Arboricultural Impact Assessment Report

Site Address: Hornsby Ku-ring-gai Hospital
1 Derby Road
HORNSBY NSW 2077

Prepared For: **Health Infrastructure**
C/- TSA Management
Level 16, 207 Kent Street
Sydney NSW

Report Number: **L1001-1**

SHEET 3 OF 3

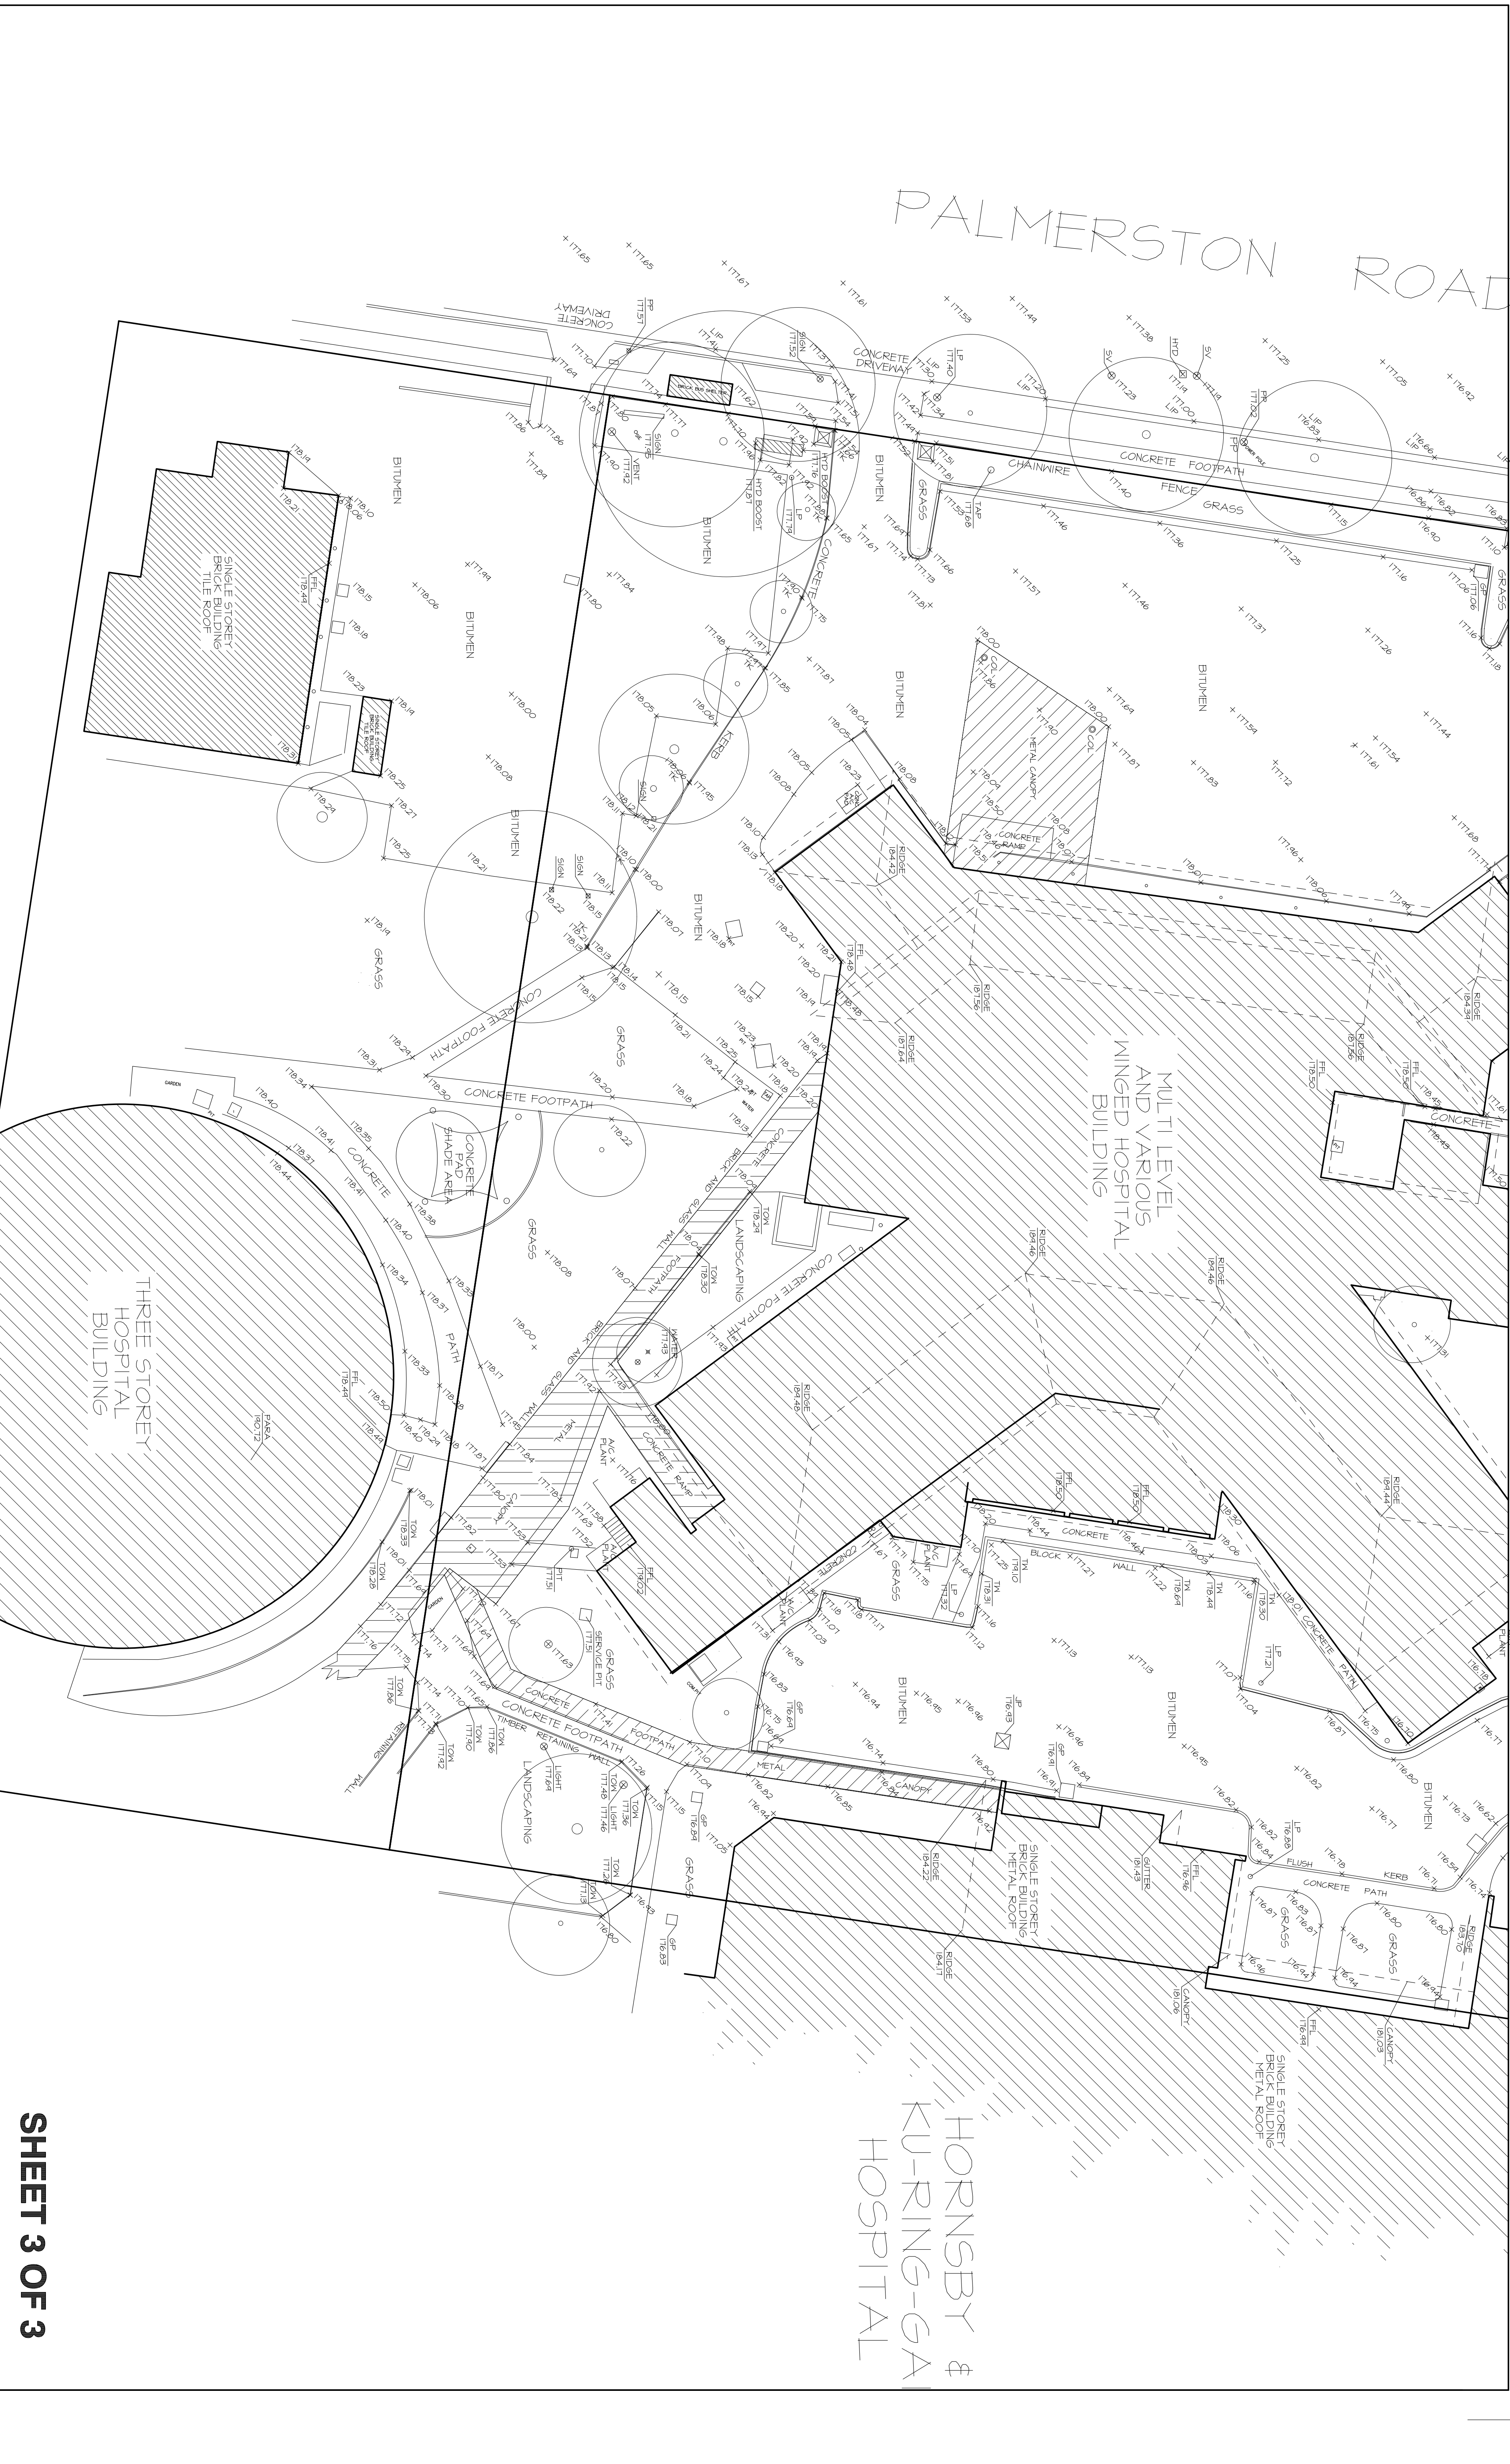
The proposed development involves demolition of the existing building and construction of a new building. A total of nineteen (19) trees were inspected and assessed in preparation of this report. Of these only thirteen (13) were indicated on the supplied plans (605_001.PRO Sheets 1, 2 and 3). The remaining six (6) trees were identified on site. Trees 23 and 24 are Brush Box (*Lophostemon confertus*) trees, located within the road reserve of Palmerston Avenue and are Council owned assets. The remaining trees are all located within the subject property.

A total of nineteen (19) trees were inspected and assessed in preparation of this report. Of these only thirteen (13) were indicated on the supplied plans (605_001.PRO Sheets 1, 2 and 3). The remaining six (6) trees were identified on site. Trees 23 and 24 are Brush Box (*Lophostemon confertus*) trees, located within the road reserve of Palmerston Avenue and are Council owned assets. The remaining trees are all located within the subject property.

Elevation North LOWE ROAD

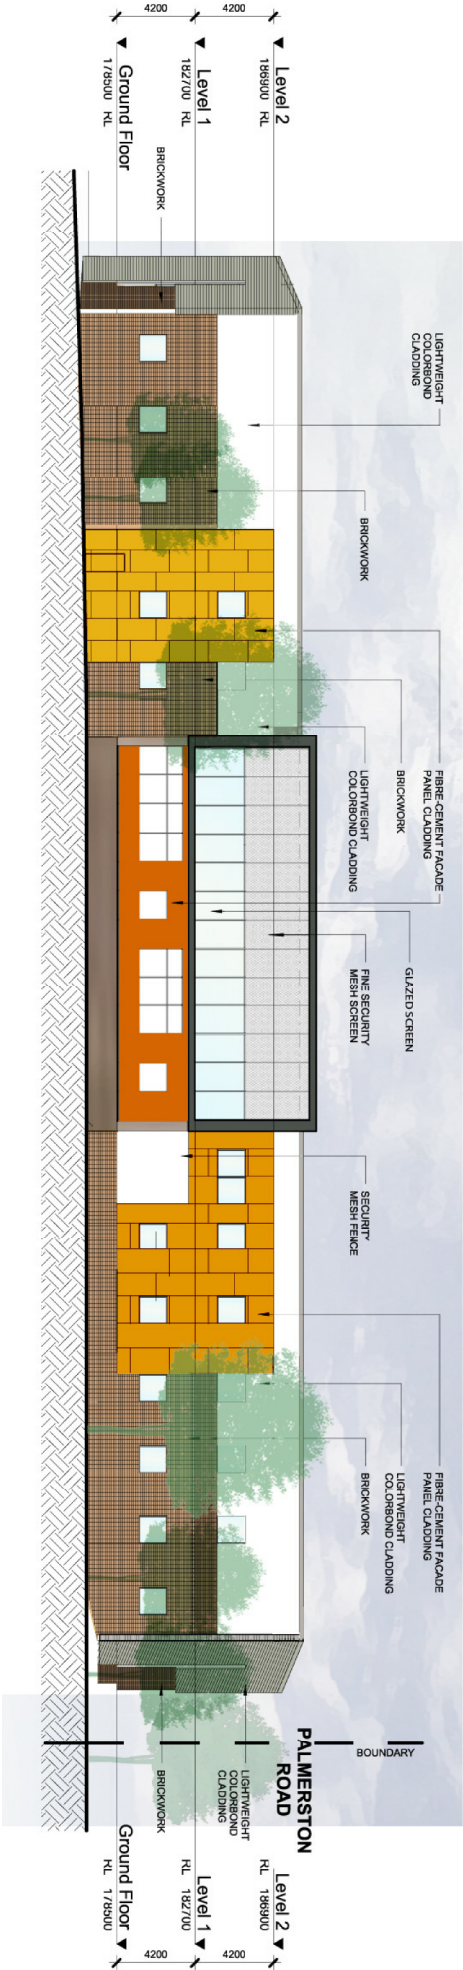
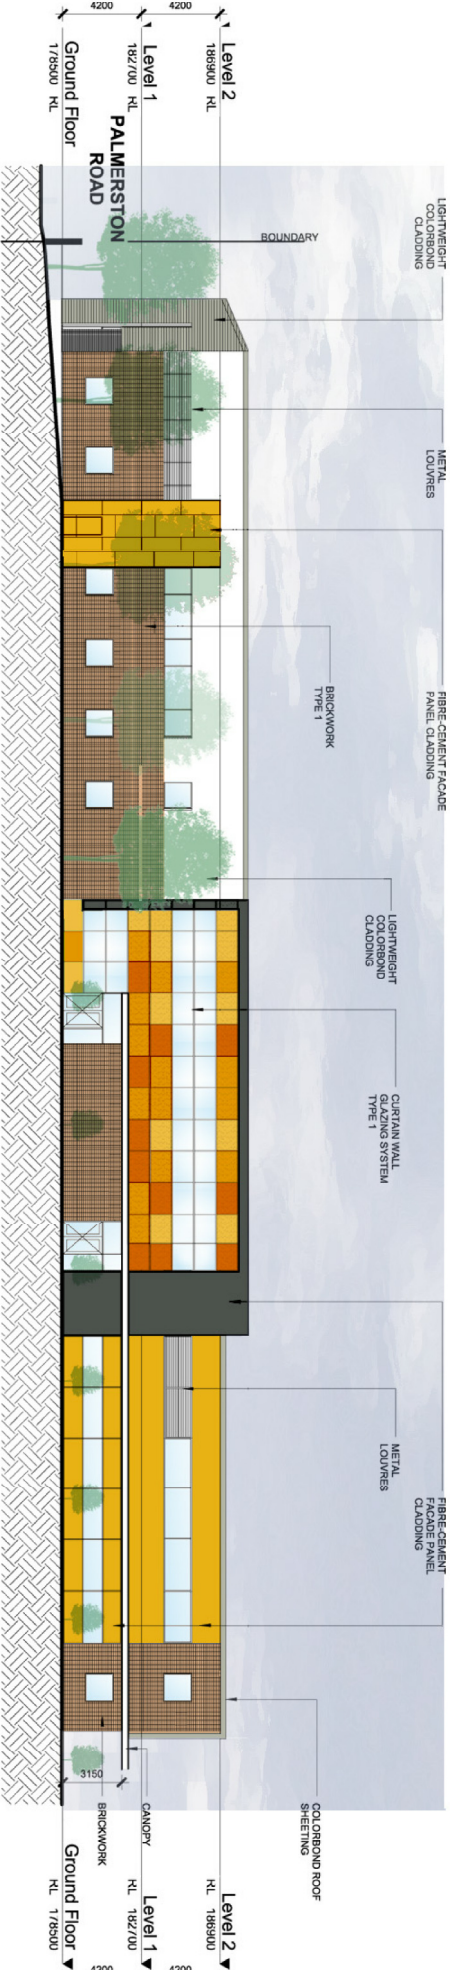
In addition to considerations given to the impact of the proposed development on the root systems of the subject trees, it is also necessary to assess the impact on the canopy of each tree. As few details regarding finished levels etc were included within the supplied plans, calculations contained within this section have used information gleaned by cross referencing the following documents;

- Elevations 01, Drawing No.: (5044) SK13a-B, prepared by Hames Sharley, dated 3 June 2011 and
- Elevations 02, Drawing No.: (5044) SK13b-B, prepared by Hames Sharley, dated 3 June 2011.

Calculations for the subject trees indicate that Tree 35 is the only tree which would be required to be pruned in excess of the acceptable 10% limitation. In this instance however, construction at the proposed distance from the subject tree would require removal of approximately 46% of the total canopy. This would not only be injurious to the health and vigour of the tree but would compromise its aesthetics irreparably. Additionally, if the tree were to survive removal of this level of canopy, ongoing maintenance pruning would be required to maintain clearances between the building and the tree. Due to the growth habits of this species, and regardless of the negative implications to its health and vigour, such maintenance pruning would be laborious and costly. Given the function of the site and the apparent level of arboricultural expertise currently engaged there a pruning regime such as this is not only financially inappropriate but practically not applicable. Taking into consideration the implications of the required pruning, retention of this tree as indicated on the supplied plans is not only unlikely but impossible should the project be approved in its current format. It is recommended that the building be redesigned within the constraints presented by this tree and allow for its retention and protection.
